Land North of Toddington Lane

Response to WSCC Consultation Response

Planning Application LU/417/21/OUT

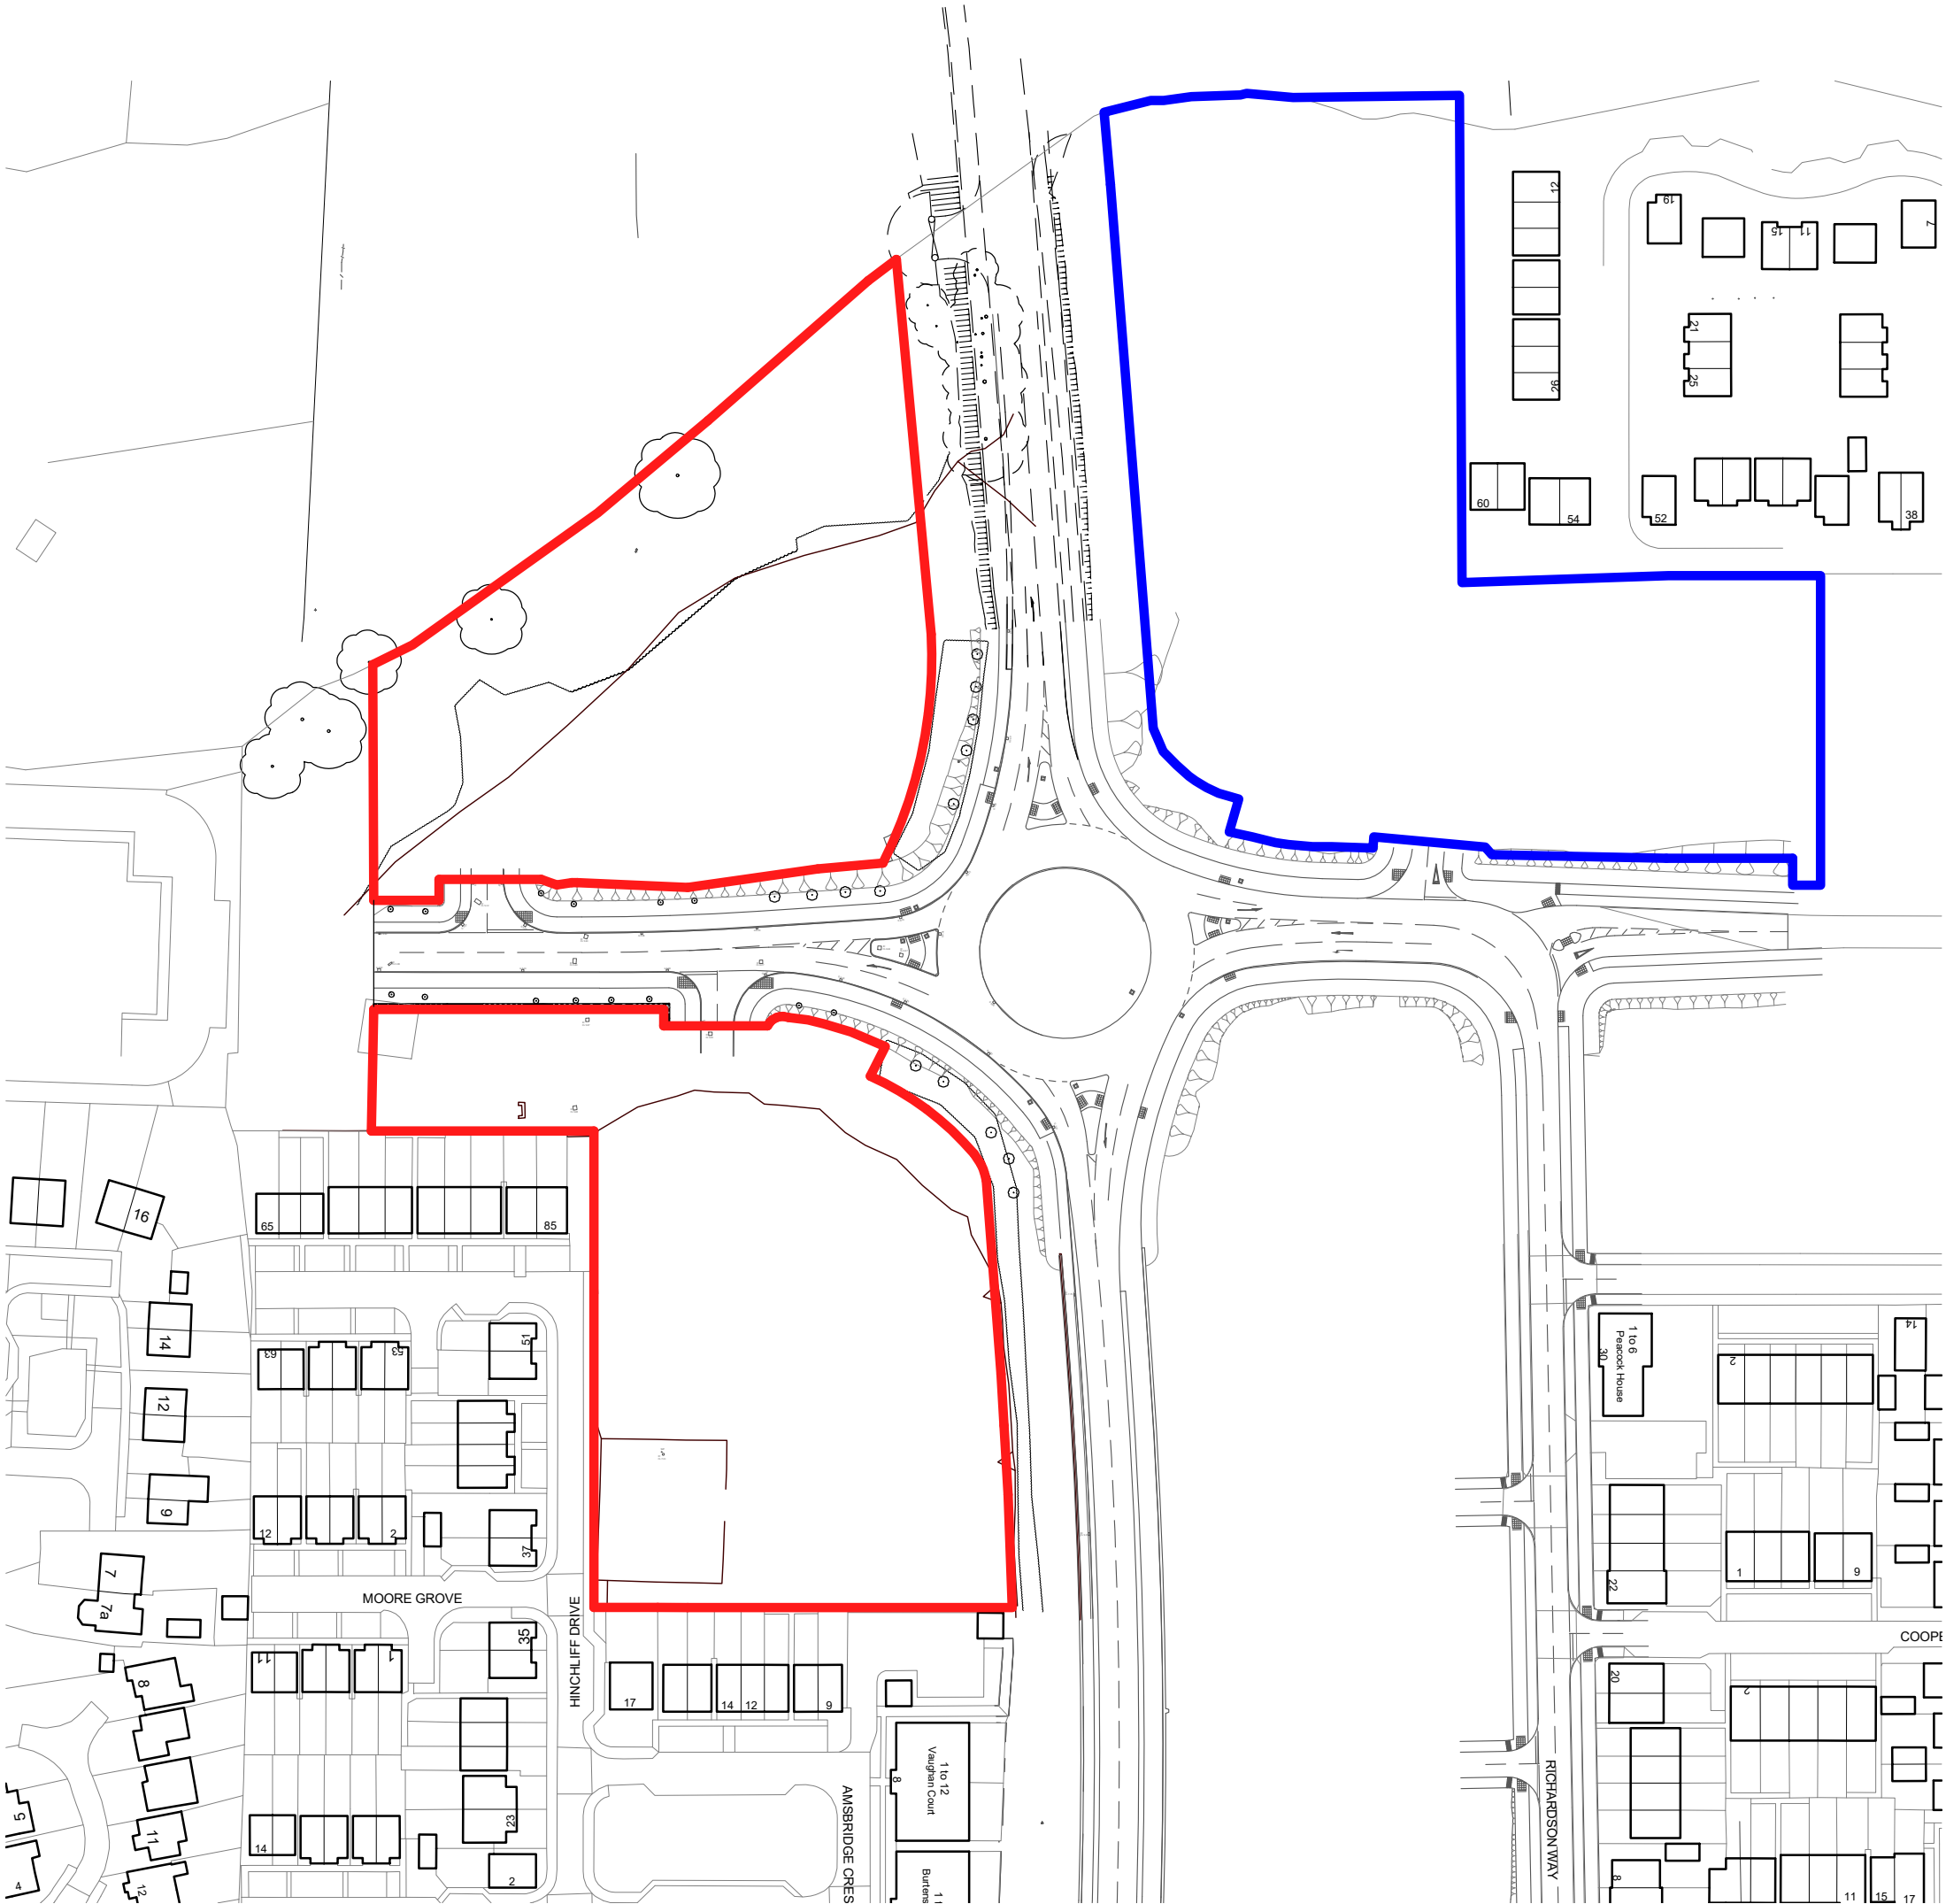
3. For the outline residential application, WSCC seek more detail and enhancement of pedestrian and cyclist links into the development parcels. An amended layout plan for the residential proposal is attached at **Appendix B** with indicative pedestrian/cyclist links connecting into both parcels (A and B); and a tree relocated behind a visibility splay on the southern parcel. Internal infrastructure as to how the pedestrian/cyclist links could be delivered are shown. This detailing will be subject to detailed design at the Reserved Matters stage, but the applicant is happy to commit to linkages being formed in the vicinity of the roundabout taken directly from the 3m shared footway/cycleway facility.

8. WSCC refer to an internal path on the northern parcel linking through to the Lyminster Bypass, requesting its removal. This is a point of clarification in that the path does not link through to the bypass, and merely provides internal site access to the dwellings which sit parallel to the bypass. There is no connection to the bypass shown on the Indicative Site Plan and there is no intention to provide such.
